Submission: SSI-9406
Project: Inland Rail – Illabo to Stockinbingal

We refer to the current public exhibition of the Environmental Impact Statement (EIS) for SSI-9406, Inland Rail – Illabo to Stockinbingal Project (**Project**).

7.1 Overview of proposal features

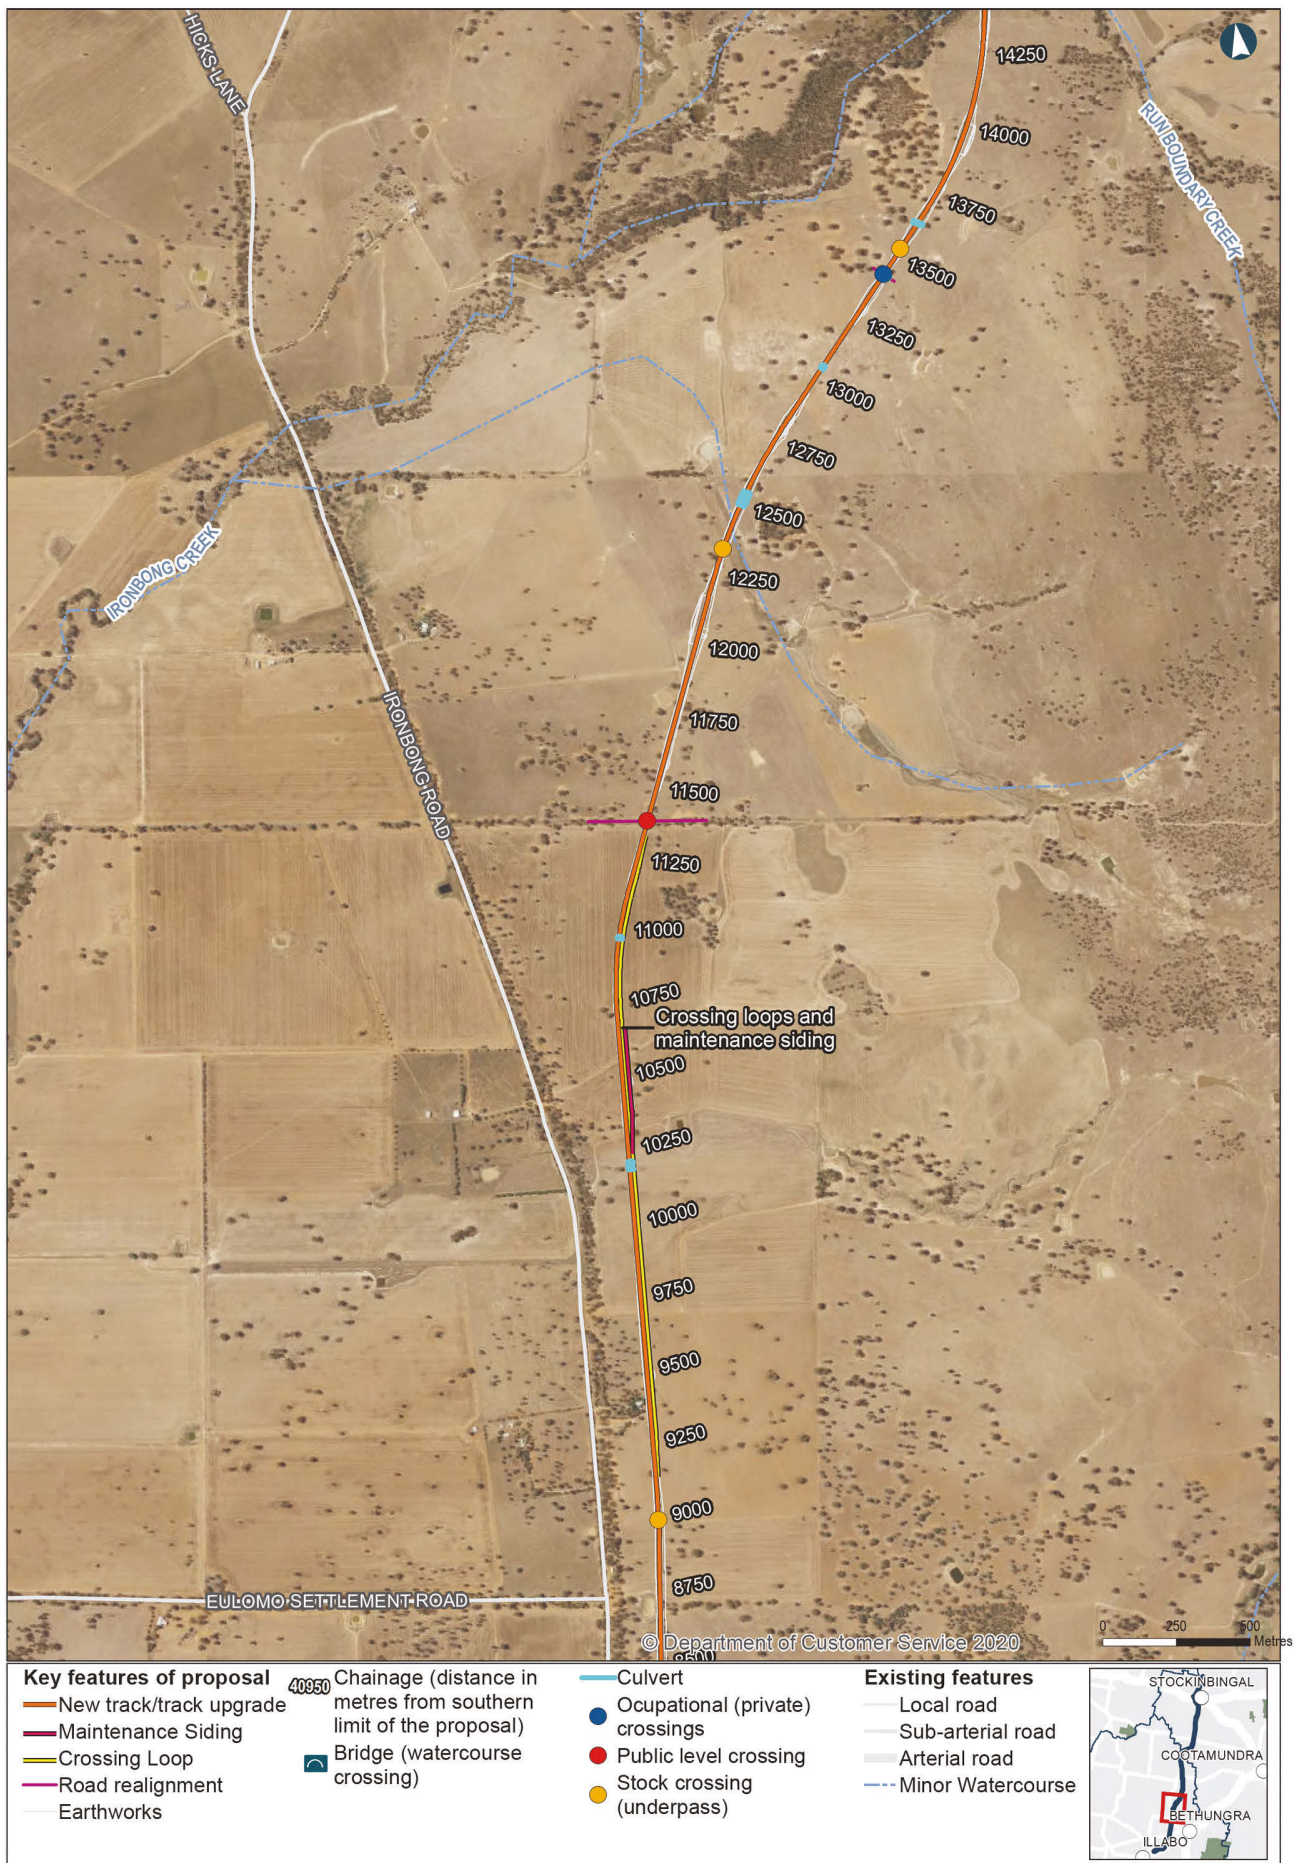
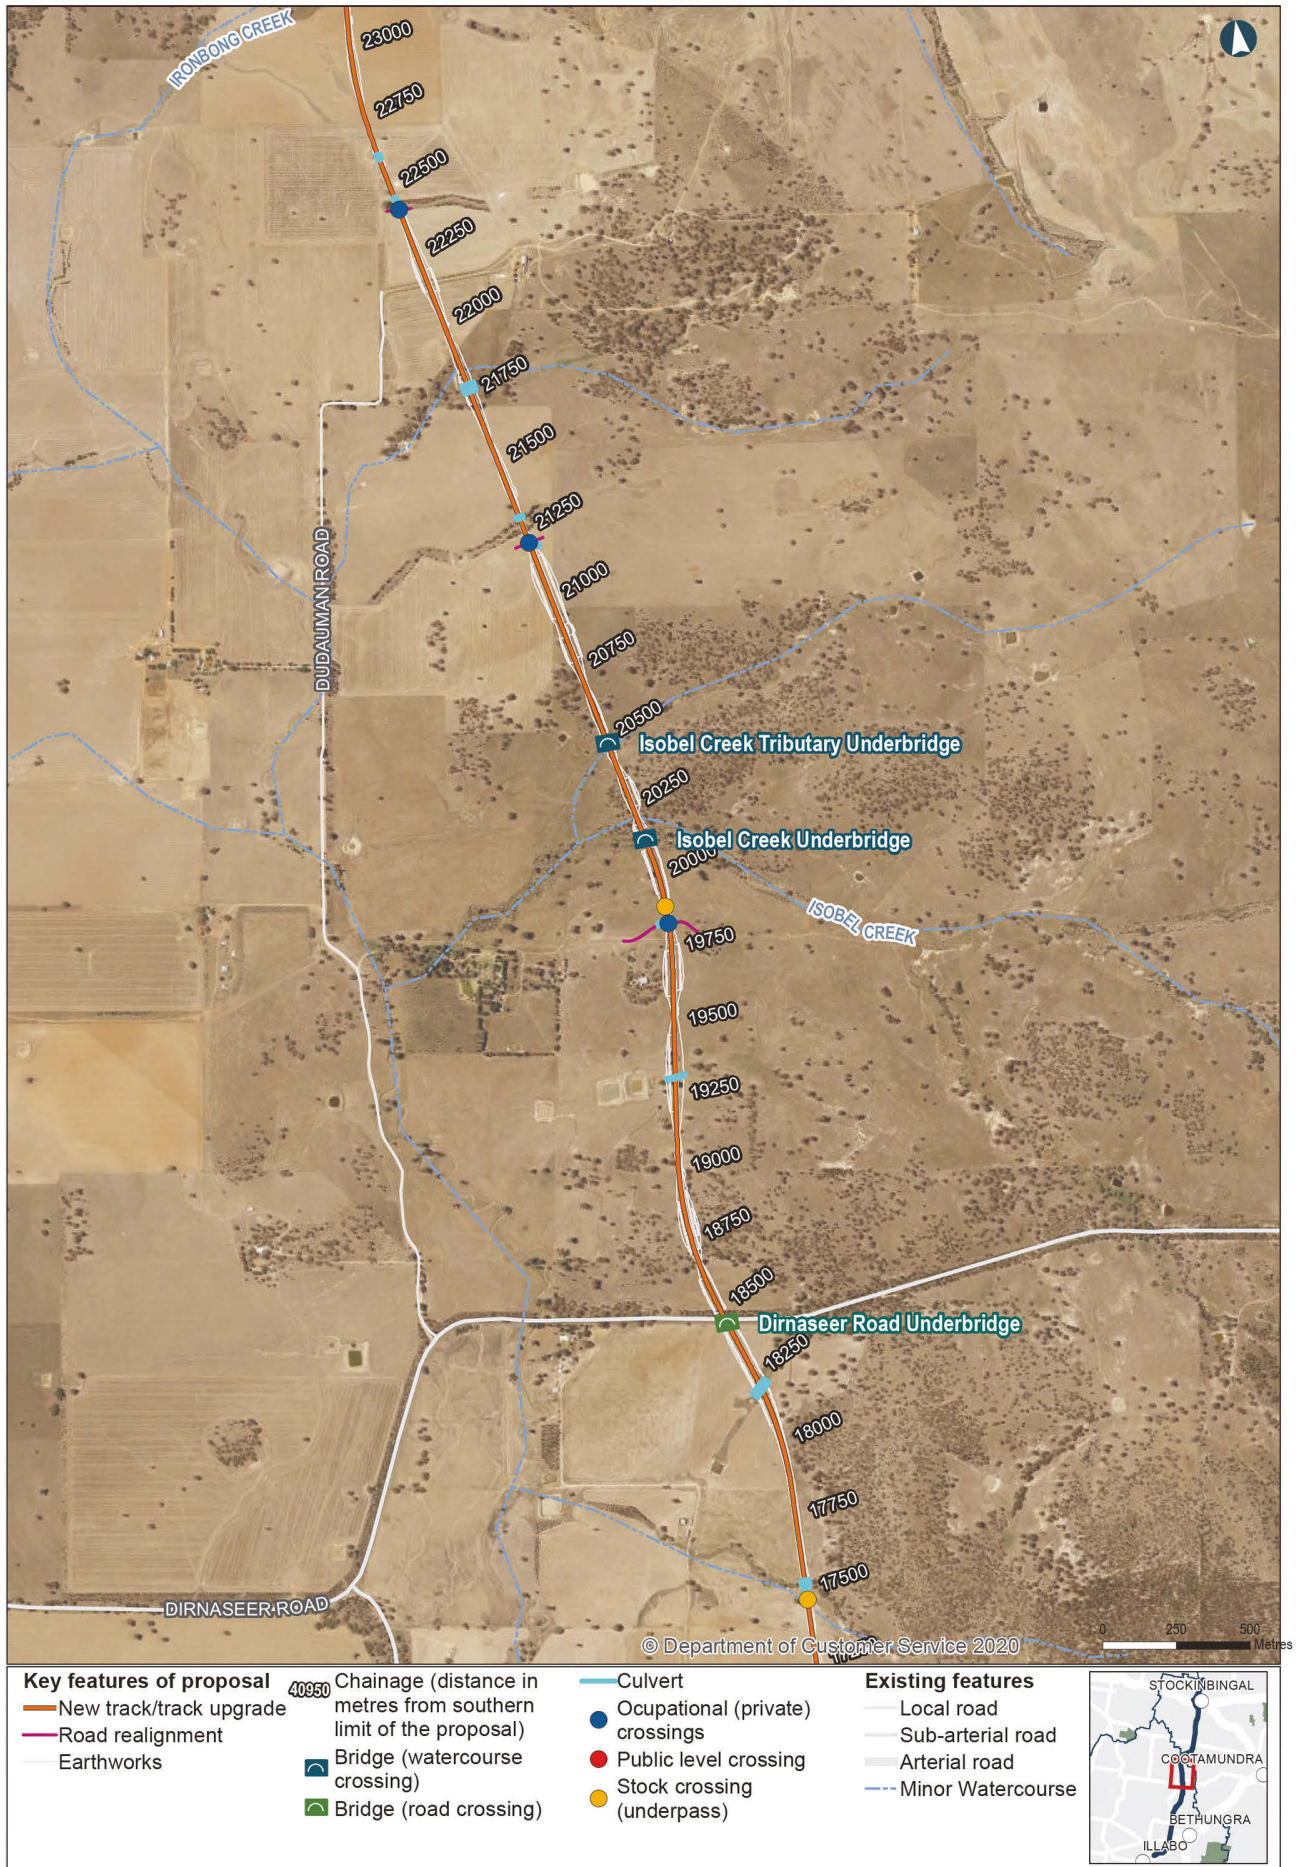
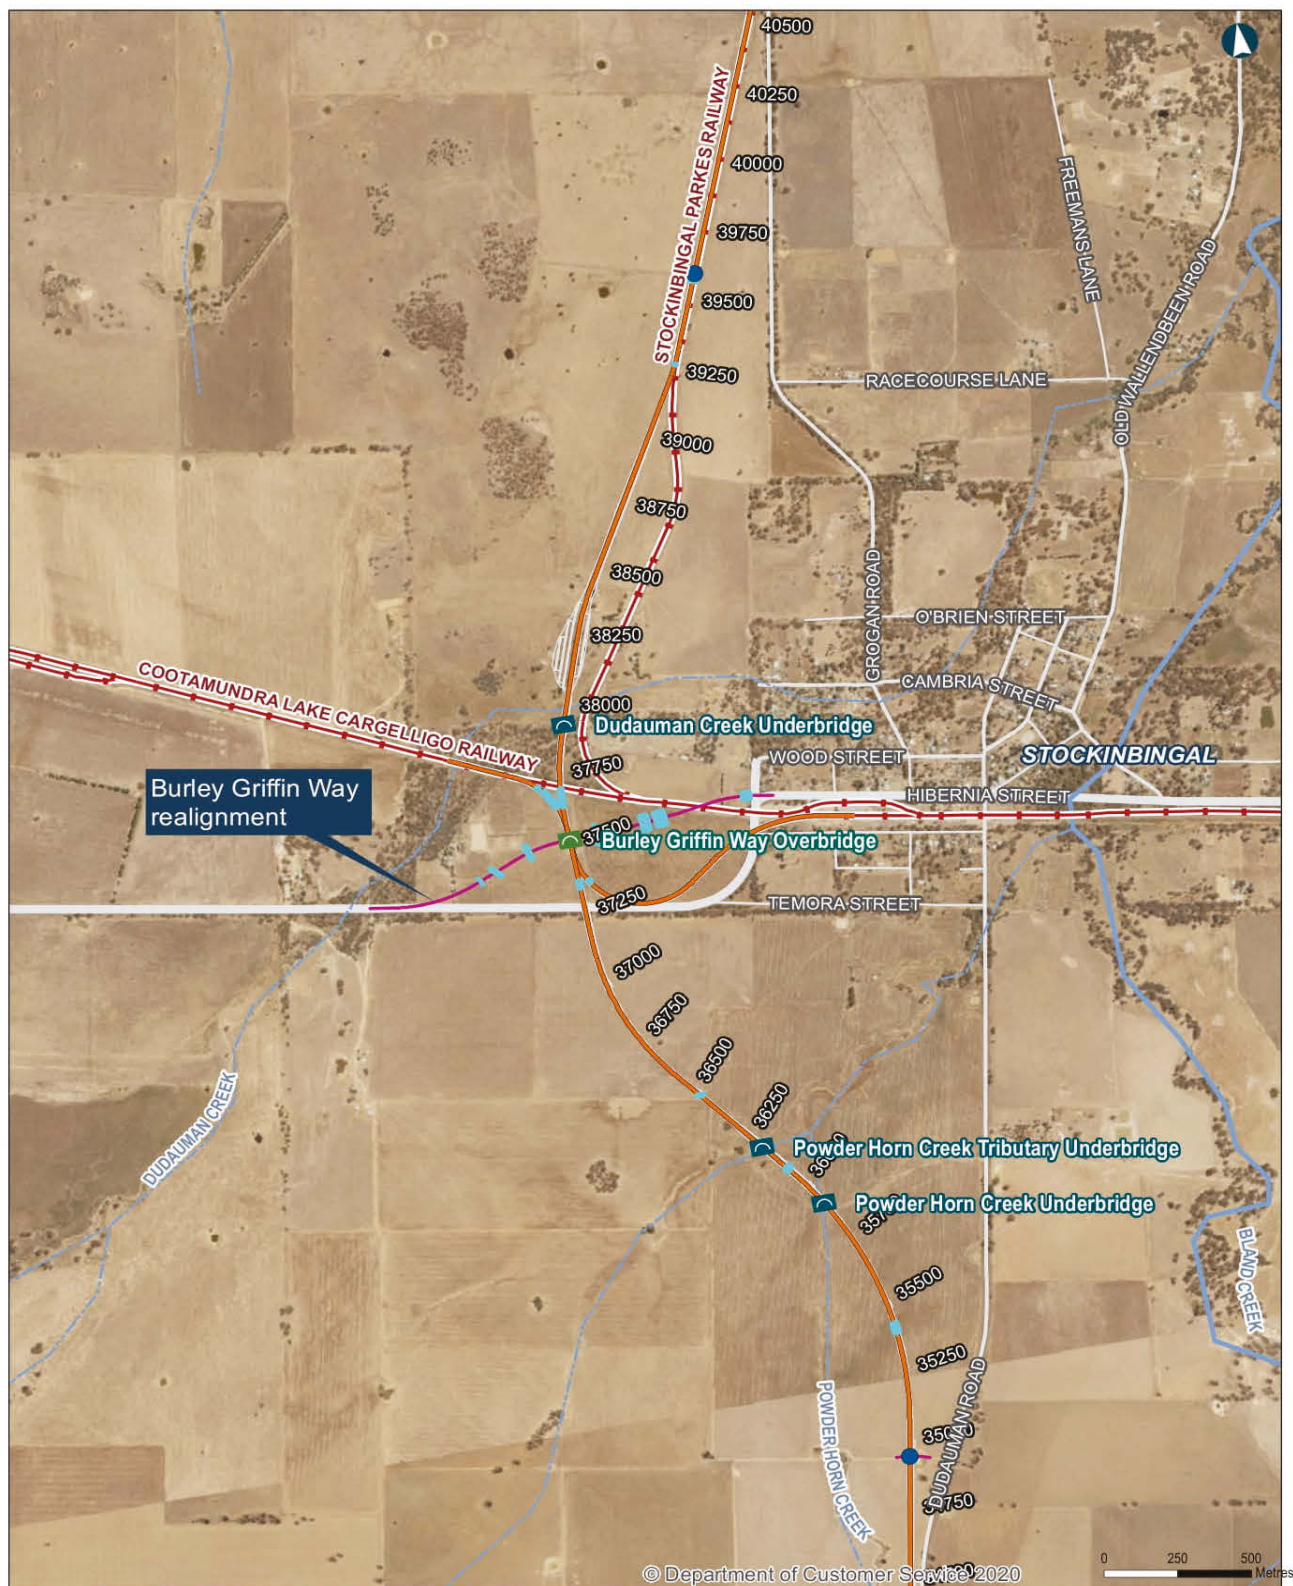
As per Chapter 7 of the EIS, the proposed track alignment and construction of the Project proposes to reduce the number of access points for crossing from [REDACTED]. The two crossings within the [REDACTED] are at chainage [REDACTED] and chainage [REDACTED] in Figure 7.1 of the EIS.

Figure 7.1 of EIS shows a culvert on [REDACTED] at approximately chainage [REDACTED].

We raise issue with the limited number of culverts across the rail alignment, which will impact the natural water flow and concentrate water in specific sections of the alignment.
